**From:**  
**To:** [Mathias Franklin](#)  
**Cc:** [DCAdmin](#)  
**Subject:** Prickleden Mill- Planning Submission ref: 2023/91491 - Letter of Objection  
**Date:** 12 July 2023 20:31:19  
**Attachments:** [Prickleden Objection letter110723.docx](#)  
[Prickleden Mill Accommodation Schedule 2023.xlsx](#)

We are writing to object to the planning application lodged at **Prickleden Mills ref:2023/91491**

SECTION D-D 1:200

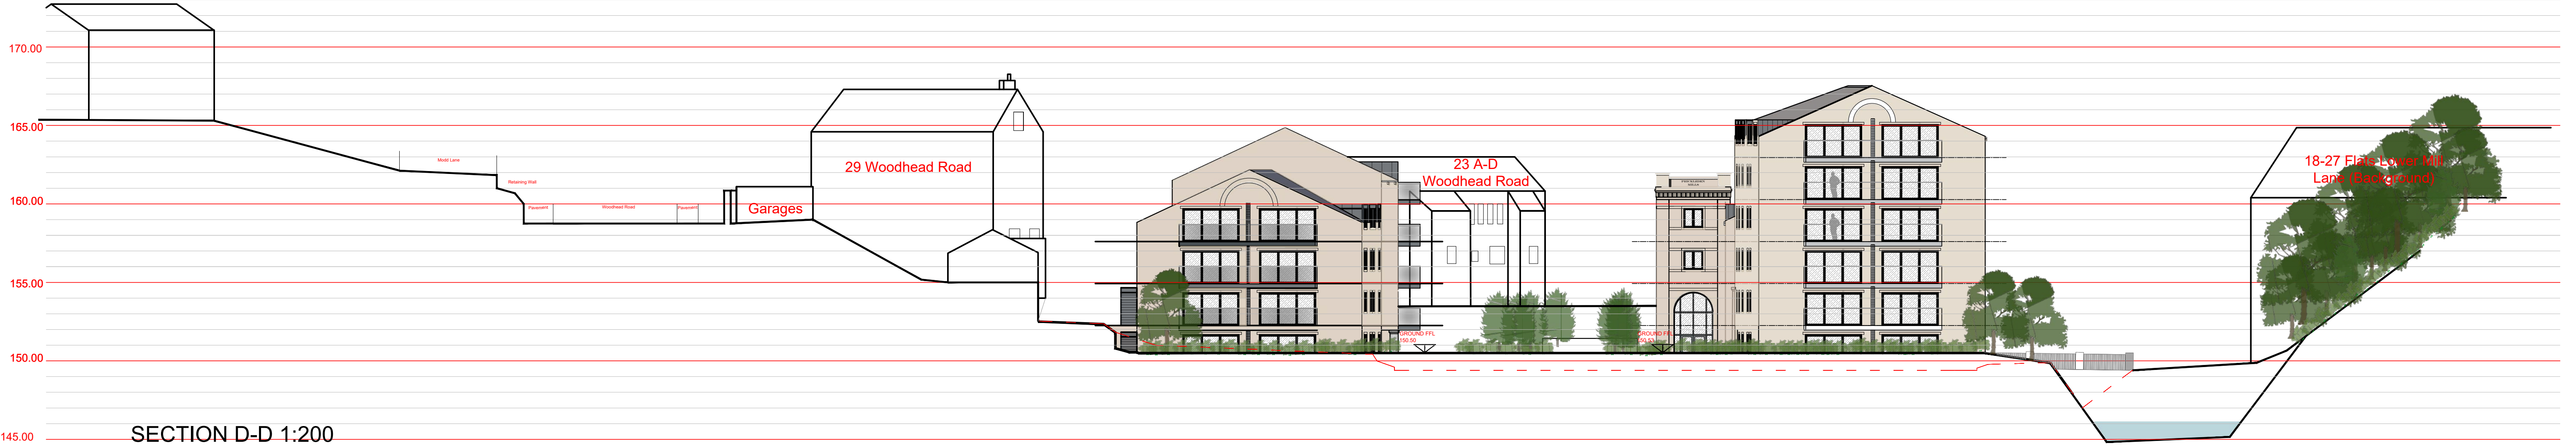
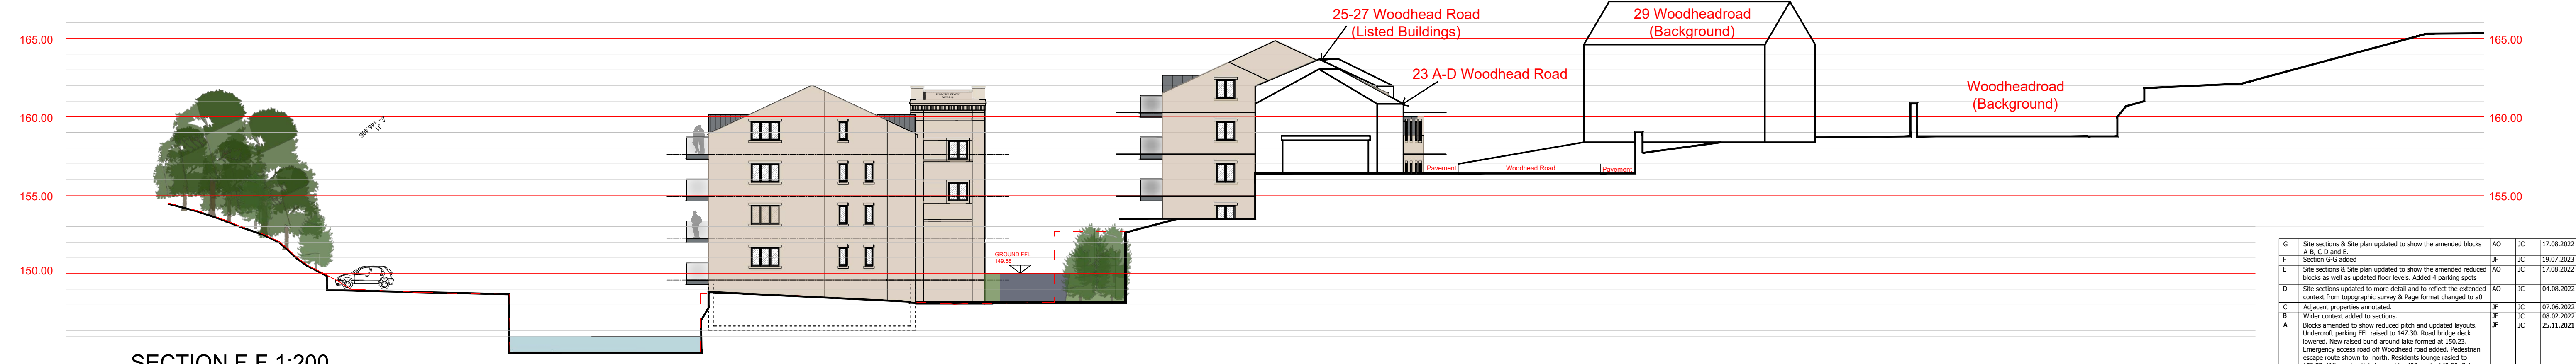
5. The eaves height of the revised proposal in places is up to 170m AOD making it in places 3 storeys higher than the consented scheme. . Some of the buildings proposed will exceed the height of the Listed Buildings at 25-27 Woodhead Road which will be dwarfed and obscured by these revised proposals in further offence to policy LP35.

6. The existing ground level is proposed to be raised by up to 3m to accommodate underground car parking . Aside from exacerbating the problems of height, scale and massing of the proposals, this is in contradiction to policy LP20 for Sustainable Travel with its prioritisation of private vehicles in direct contravention of the policies set out in the hierarchy in the policy itself.

10. The proposal may be in breach of policy LP28 Drainage. The developer should be required to demonstrate outline proposals on how SuDS will be implemented , and should not be permitted to raise the Ground levels and especially not by the enormous amounts shown in the plans.

VIEWPOINT 4 - GREENFIELD ROAD

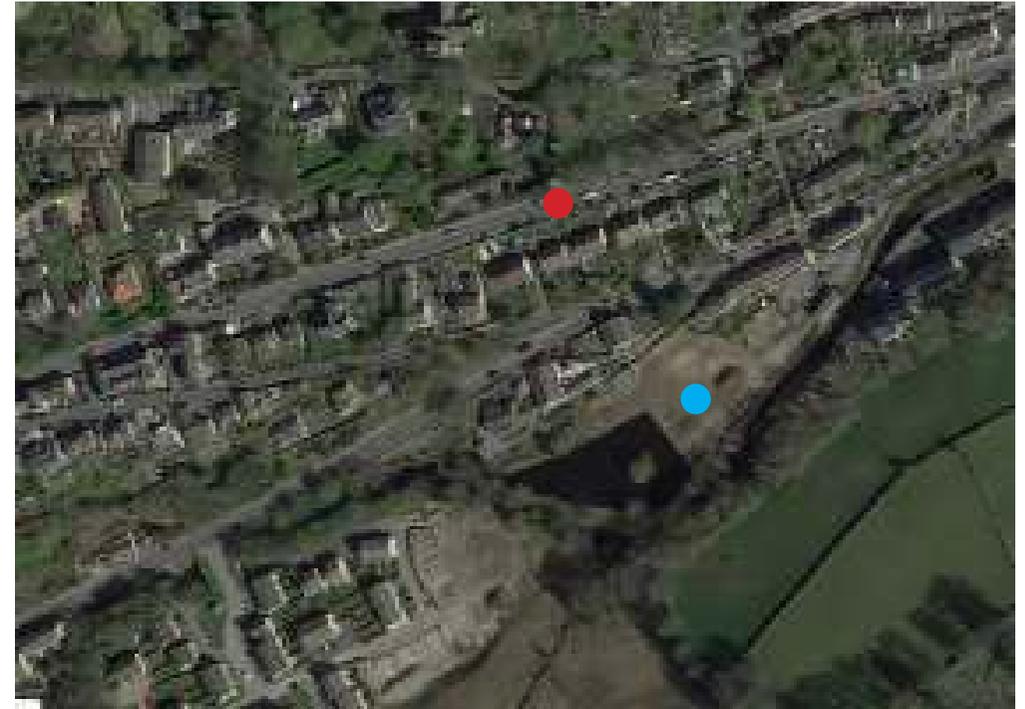
15. The Visual Impact Assessment does not contain verified views. It qualifies itself by saying the ridge heights are 'approximate'. It does not show the proposed buildings (easily done with today's CAD and photoshop programmes) in the images. Please ask the developer to resubmit it with the proposed buildings inserted into the photographs. Otherwise it has very limited value.

All viewpoint photographs feature trees in full leaf, which is clearly approximately half the year at most . In Autumn, Winter and early Spring the development will be even more intrusive.
